From: Tom Dixon [REDACTED]
Sent: 24 November 2017 09:15
To: Richard Temple
Cc: David Hawkins; Alex Hurn
Subject: RE: Planning Application: BR/218/17/PL : 12 London Road - Planning update 10/11/2017

From: Richard Temple
Sent: 10 November 2017
To: Tom Dixon
Subject: RE: Planning Application: BR/218/17/PL : 12 London Road - Planning update 10/11/2017

Subject: Acknowledgement of Planning Application: BR/218/17/PL : 12 London Road

NORTH EAST ELEVATION

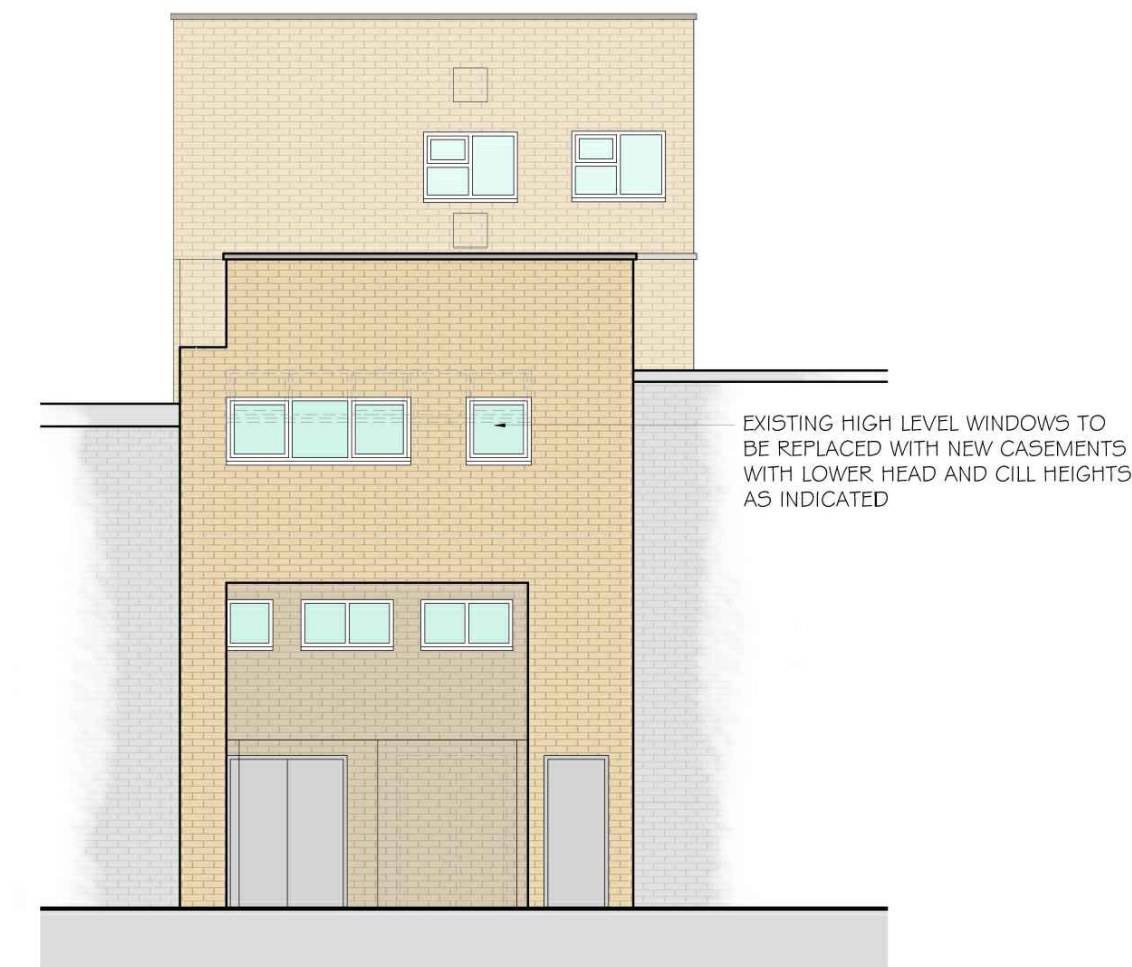
Require a street scene (this doesn't have to be 'fully fledged' if that means the whole street but needs to be more detailed than current) so we and potentially members of the public, planning committee & town council can assess the impact on the street scenes. Even if to just show the limited impact it is worth having. Obviously I can't force you to provide one.

- Could a clearer proposed front elevation be provided, please? On the proposed plan it's very hard to see it and may be an issue for the town Council and public when viewing the application.

- Is bicycle storage to be provided for the flats?
- Can you provide a proposed street scene elevation from front (north east) and rear (south west) please?

Please find attached a detailed street scene and larger elevations as per your request.

In response to your earlier comment, we will send over clearer elevations for your convenience shortly. Please may you also send through the acknowledgement letter again for confirmation.

I will send over a clearer plan of the proposed elevations shortly. Please feel free to contact if you have any further queries.
